DRB Application No.: **03-02000 (SBP)**
Project Name: **ALAMEDA BUSINESS PARK**
Agent: **G. Donald Dudley Architects**

**CITY OF ALBUQUERQUE
PLANNING DEPARTMENT
Development Review Board
12/3/03 Comments**

RE: LOT 9, ALAMEDA BUSINESS PARK/ SDPBP

PROJECT NUMBER: 1003114  
 Application Number: 03DRB 02000

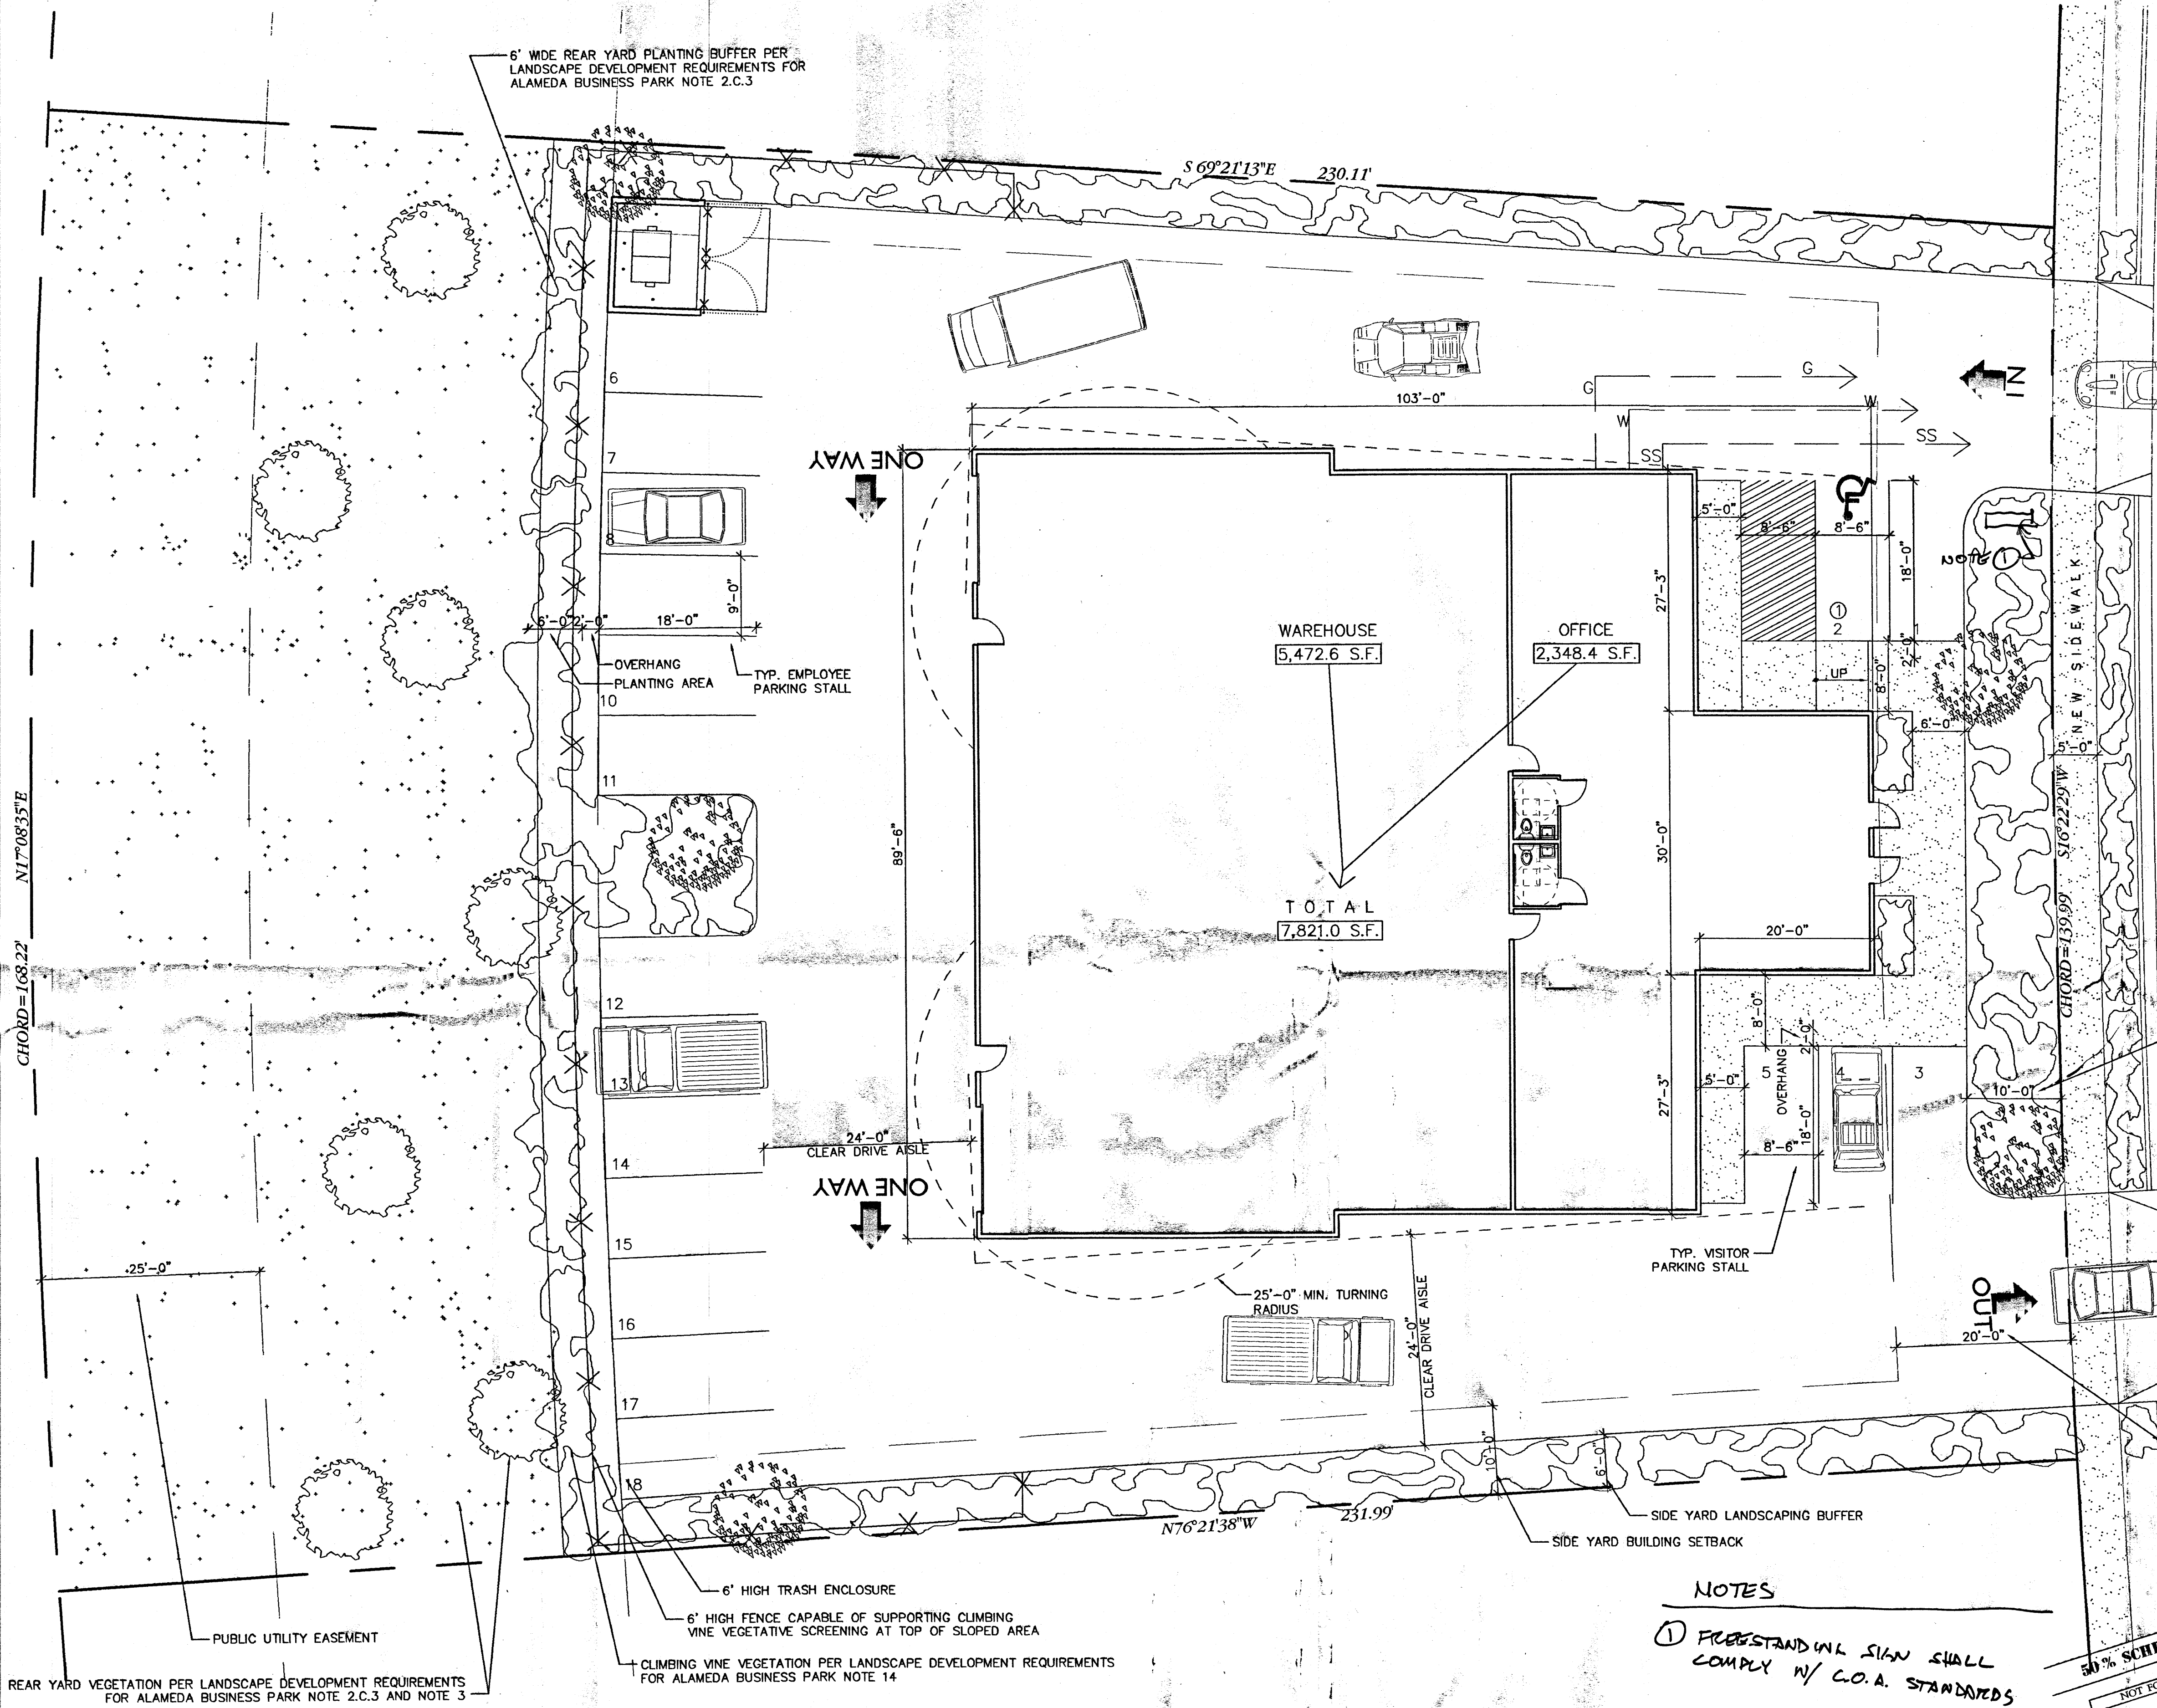
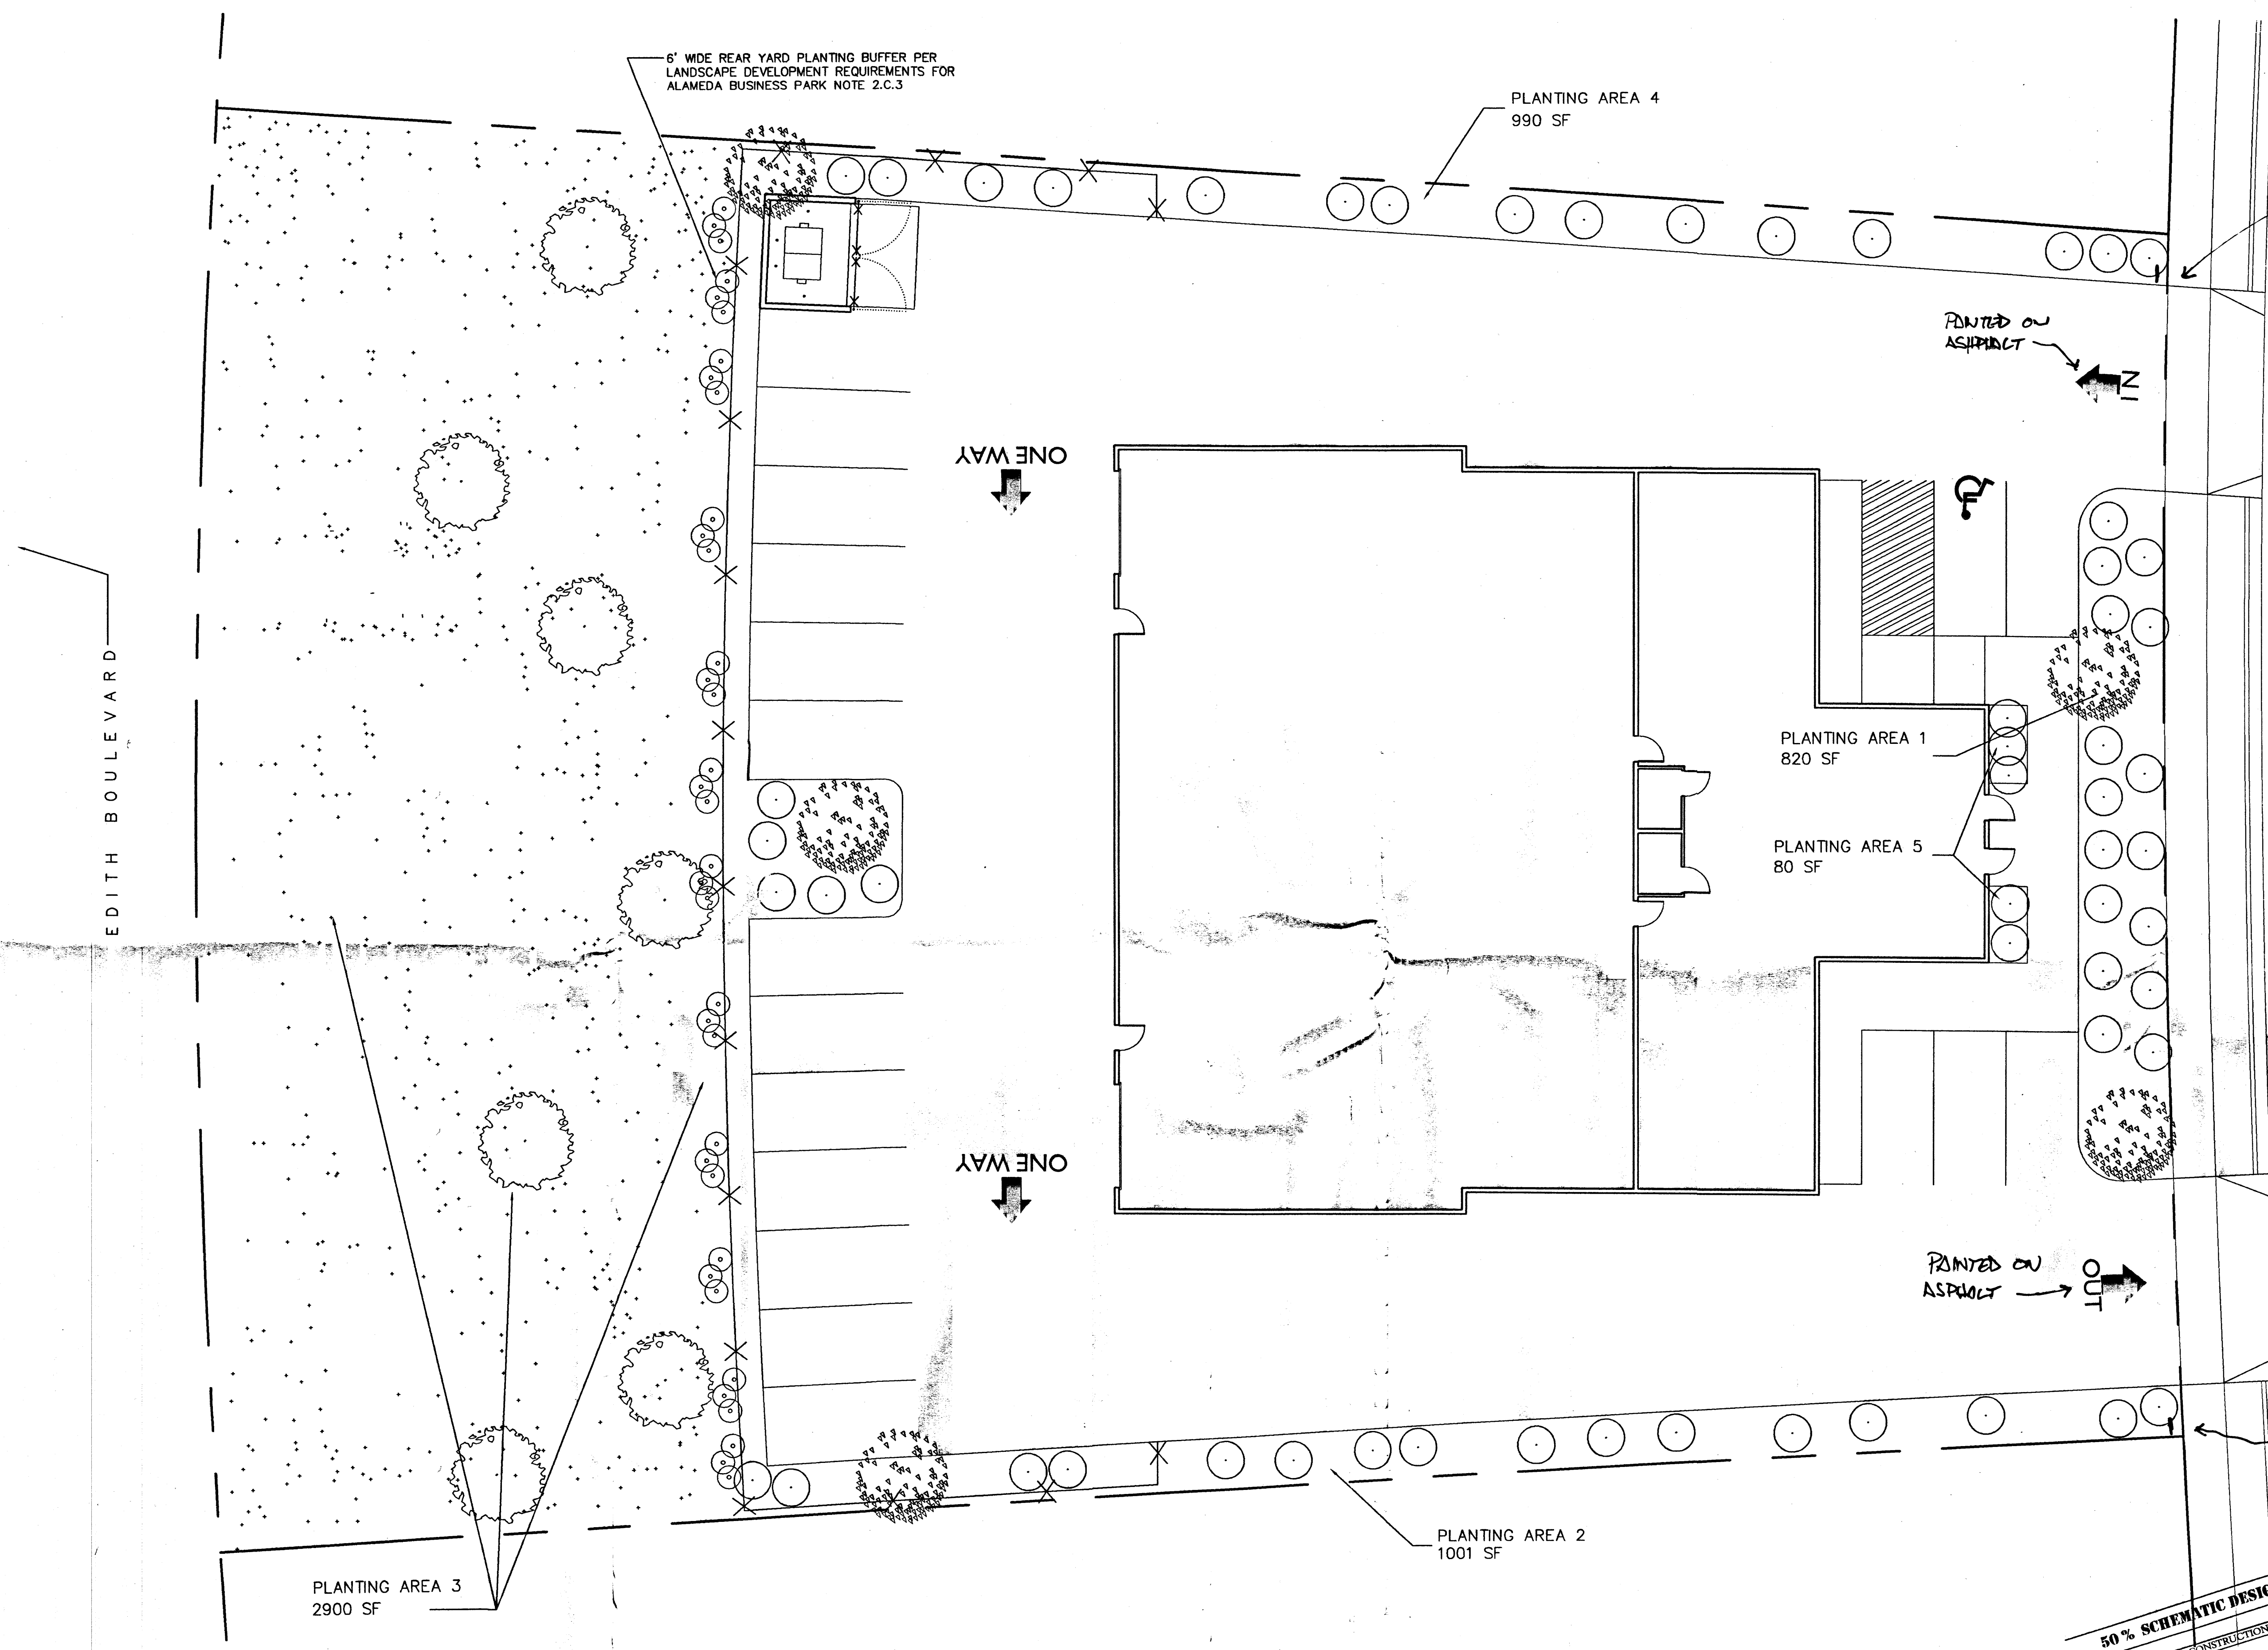
1. Each sheet should be labeled in the lower right corner by the page identification. The site plan sheet should be labeled "Site Development Plan for Building Permit".

2. The signature block should be on Sheet C1.1.
3. Place a bar scale on C1.1.
4. Identify any existing or proposed easements on Sheet C1.1.
5. Identify the square footage of each existing & proposed ^{building} ~~easement~~ on Sheet C1.1.

6. Are there any off site structures within 20 feet of this property? If so, they should be shown on C1.1.
7. An elevation drawing of the refuse container & enclosure with dimensions, colors & building materials should be included on the building elevations sheet.

LANDSCAPING PLAN

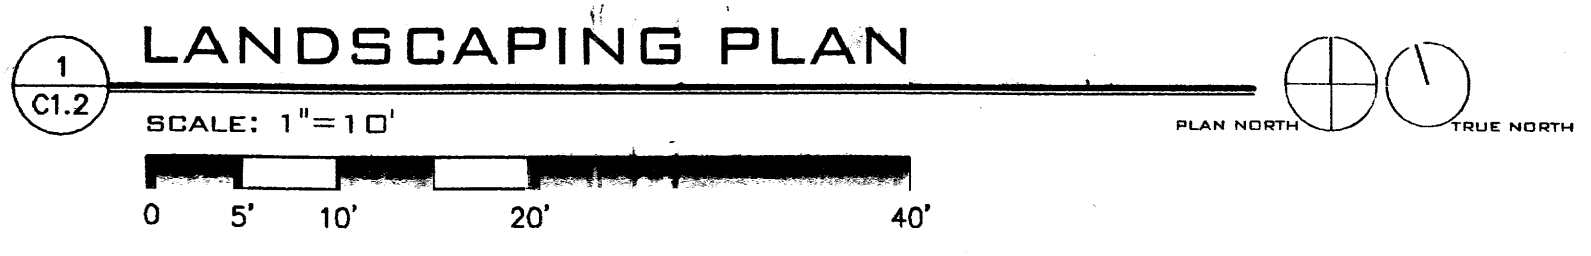
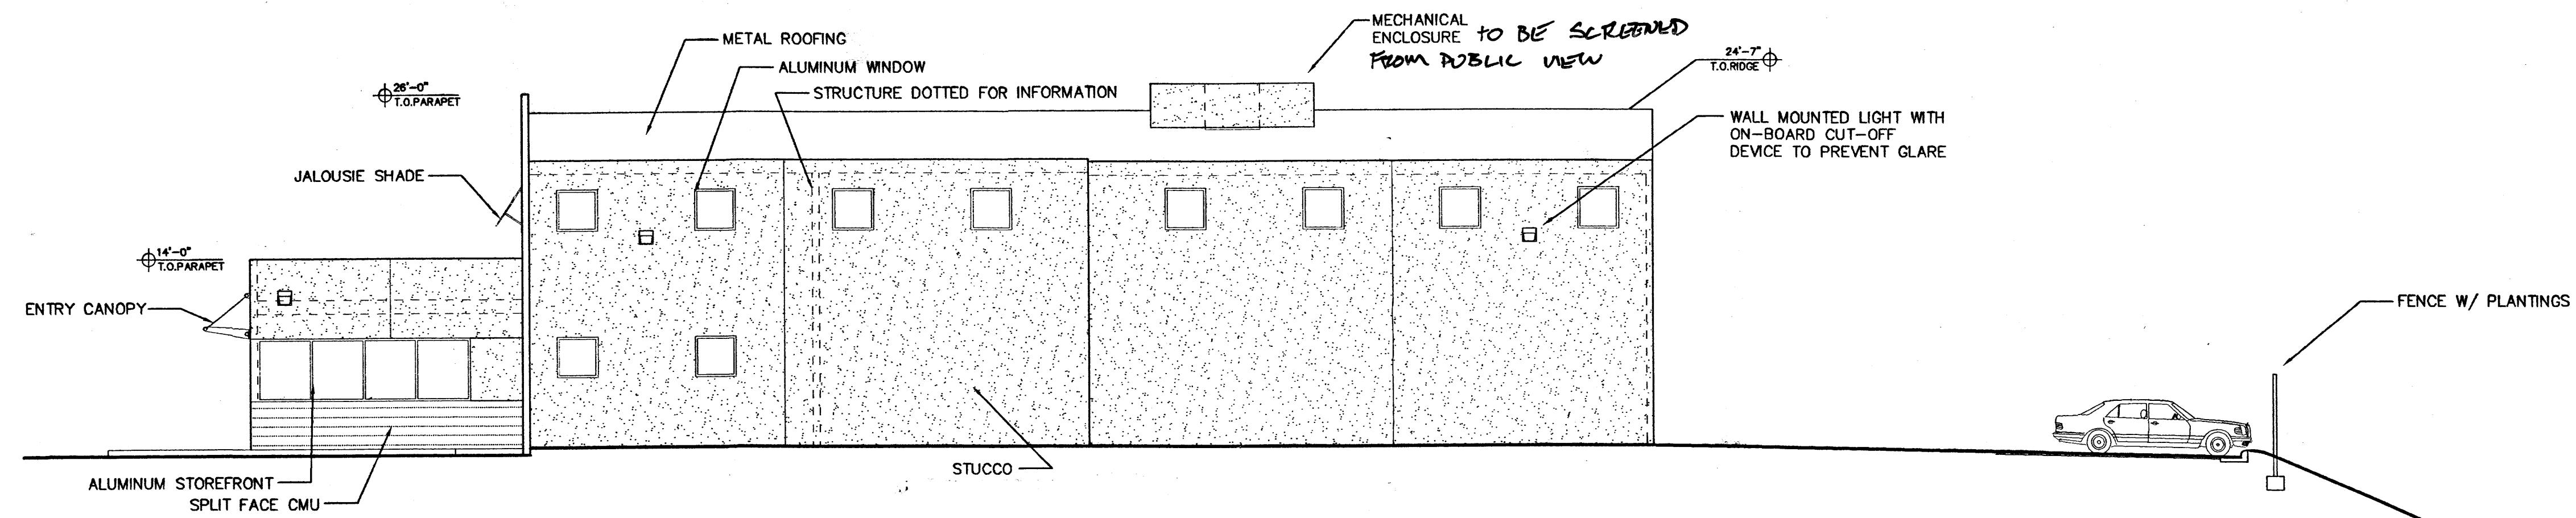
11. The Landscaping Plan should be a separate sheet with the following additions:
 - The location, species and size of each plant along with the water usage (H,M,L). A minimum of 80% should be medium or low. No junipers please.

- Describe the irrigation system.
 - List the square footage of each planting area.
 - State the maintenance responsibility.
 - A statement of compliance with the City Water Conservation, Wasted Water and Pollen Ordinances is required.
